Your Ref: OWPC23196
Our Ref: LU/126/19/PL 16-04-2019
Please ask for:
Mrs A Gardner

Demolition of the existing garage building (B2 industrial use) and redevelopment of the site providing 9 no C3 residential units - This application affects the character and appearance of River Road Conservation Area.

25 River Road Littlehampton

Thank you for your internet representation made on 27th May 2019 which has been recorded as '**an objection**' with the comments as follows:

PROPOSED DRAWINGS:
Terminus Place
Proposed & Existing Street Scenes

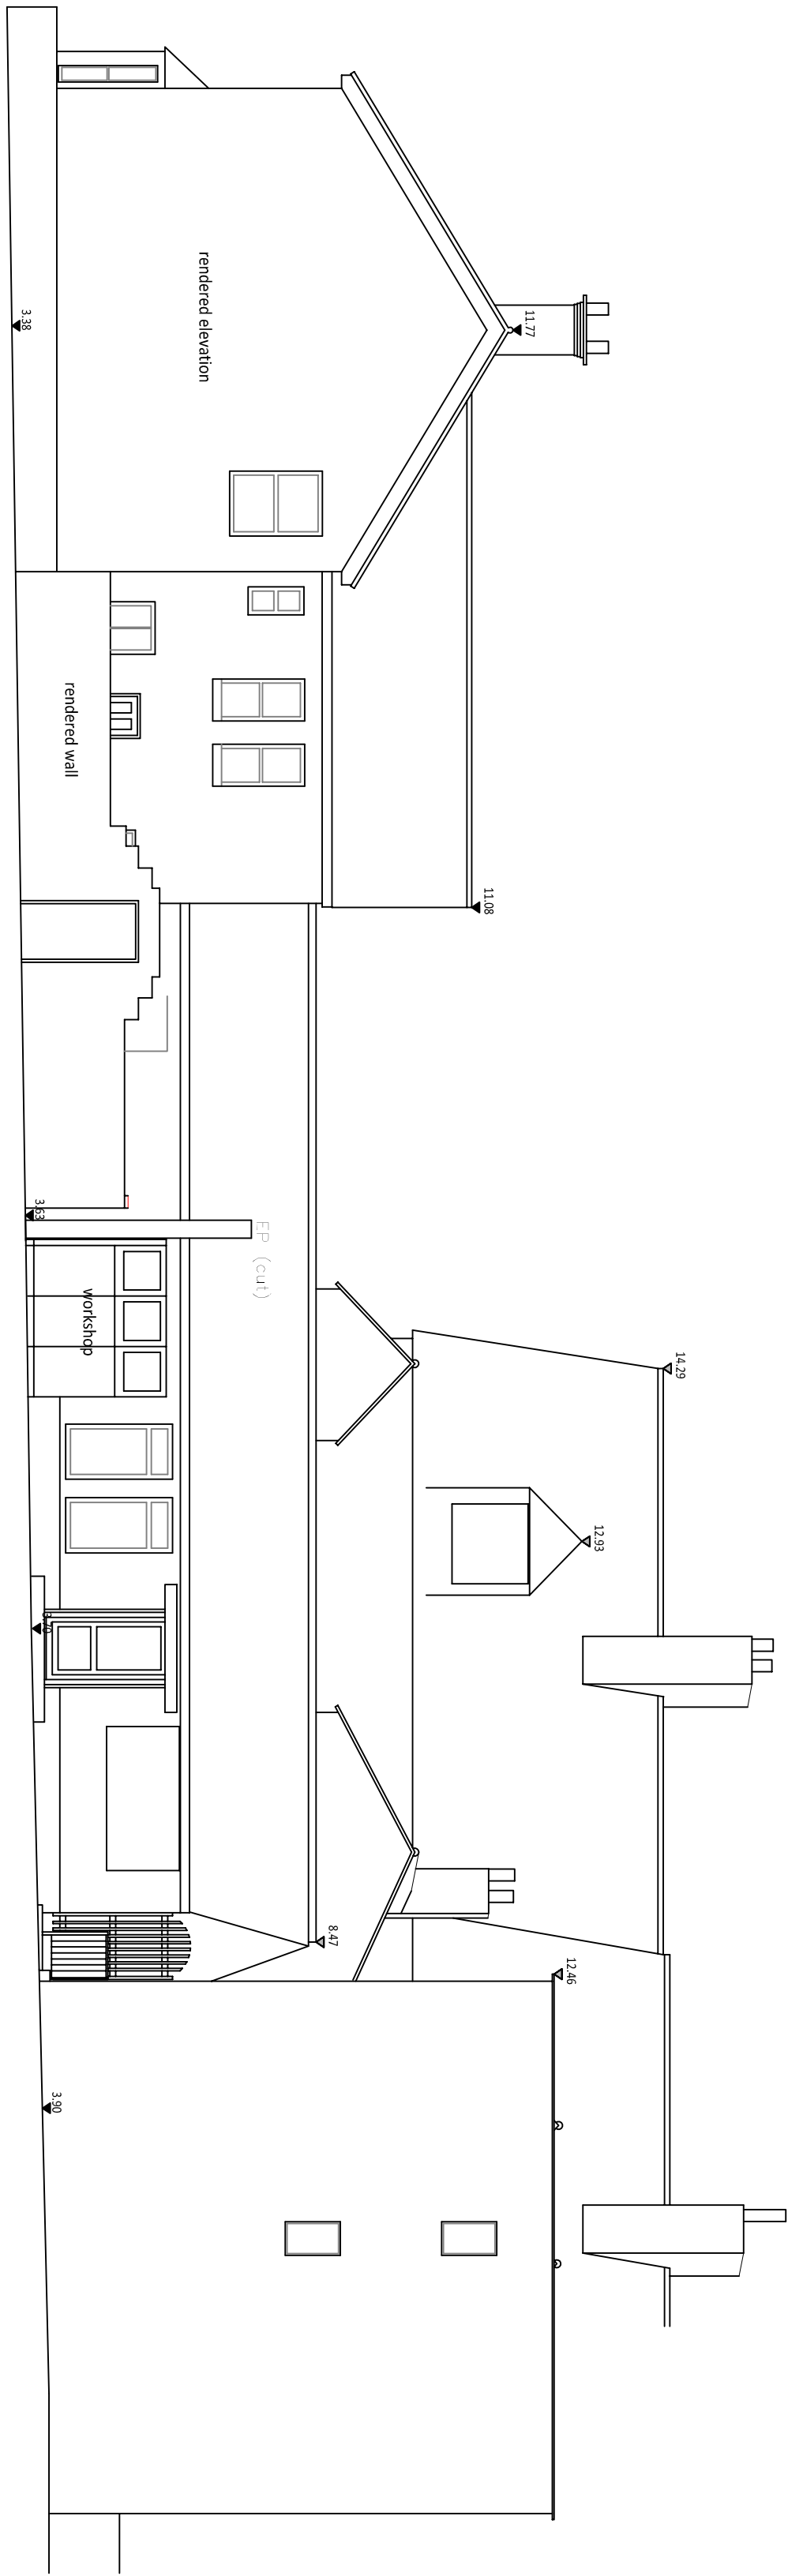
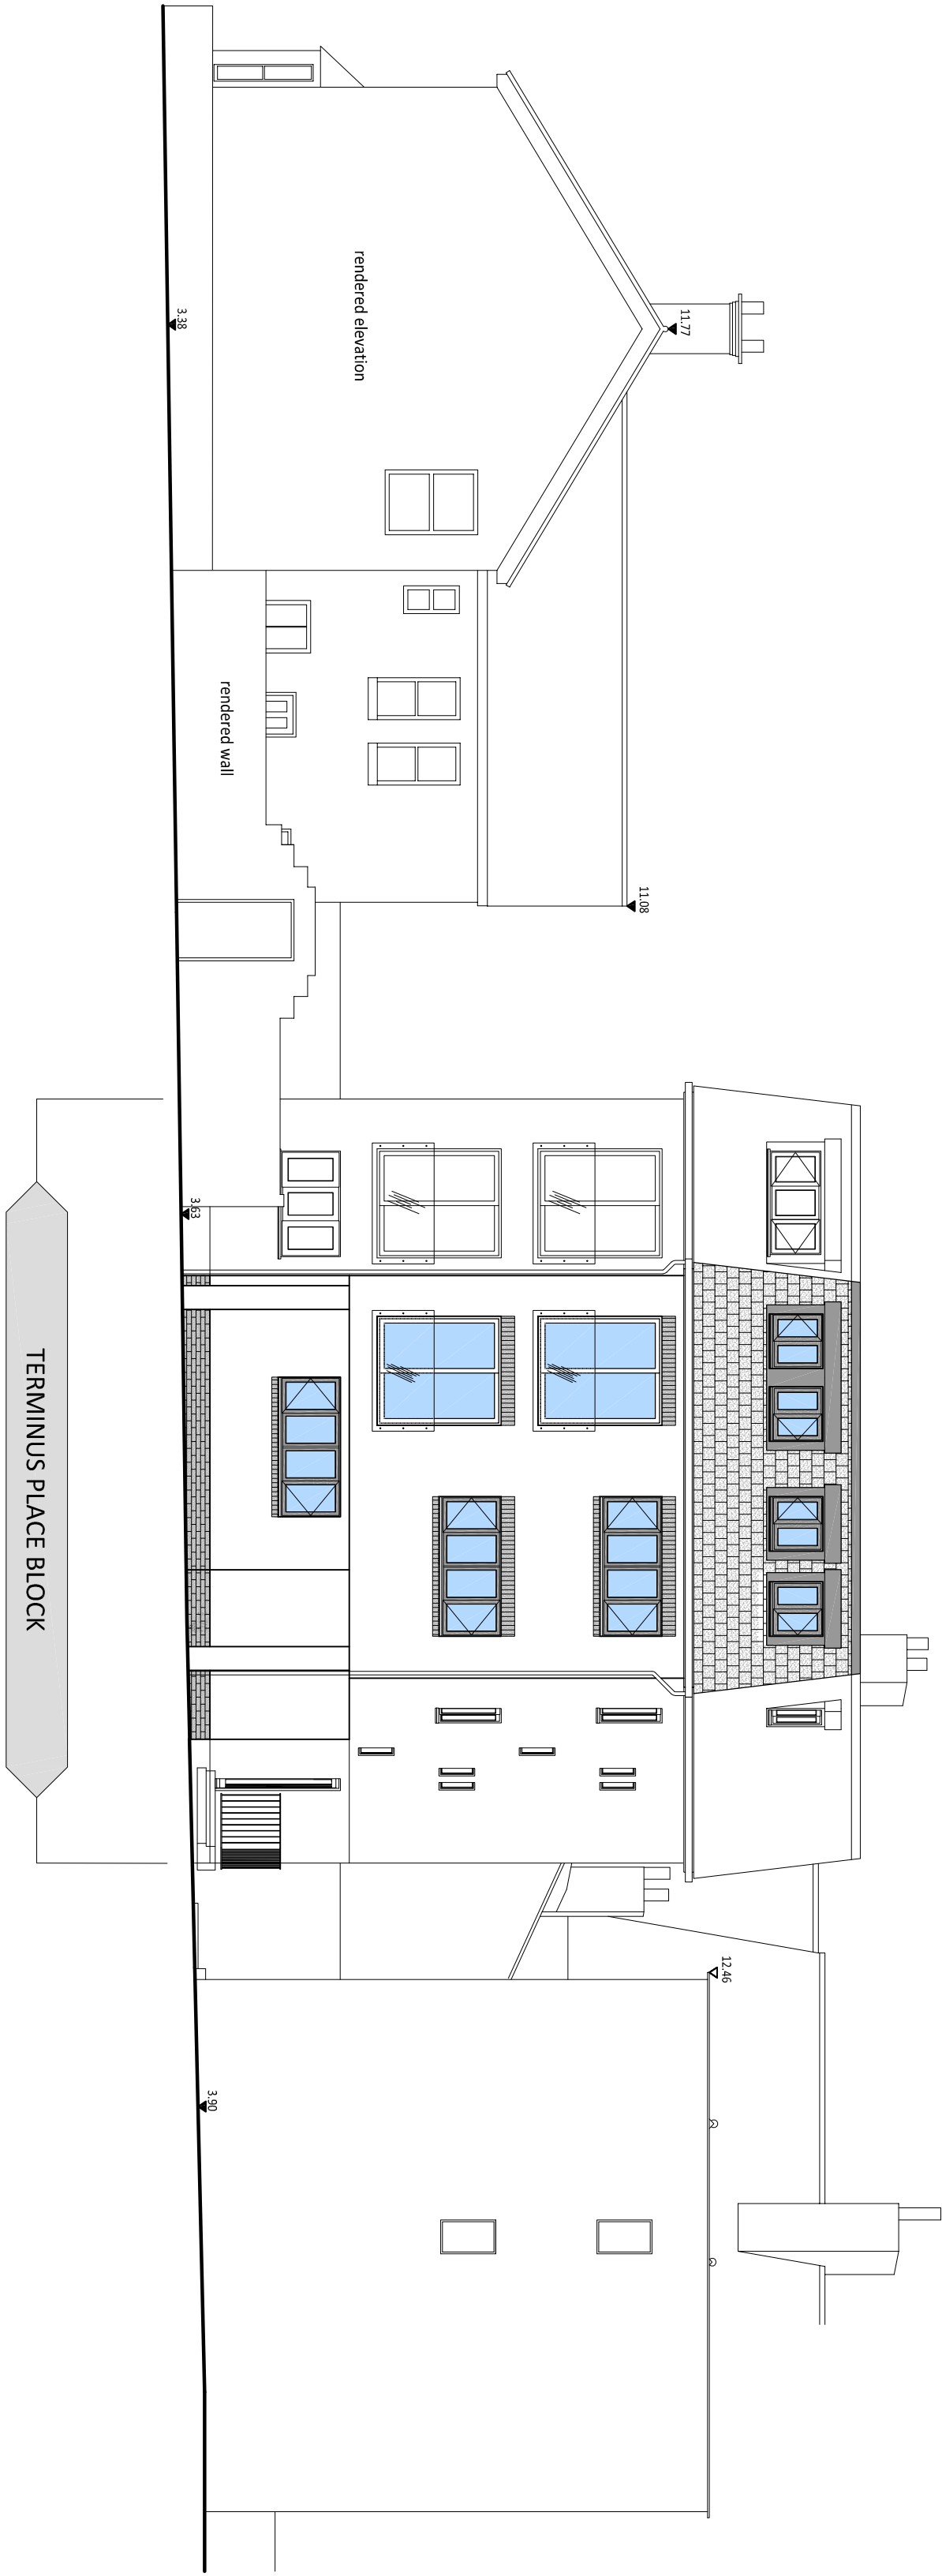
3a The height of the development is over 1 third higher than existing properties
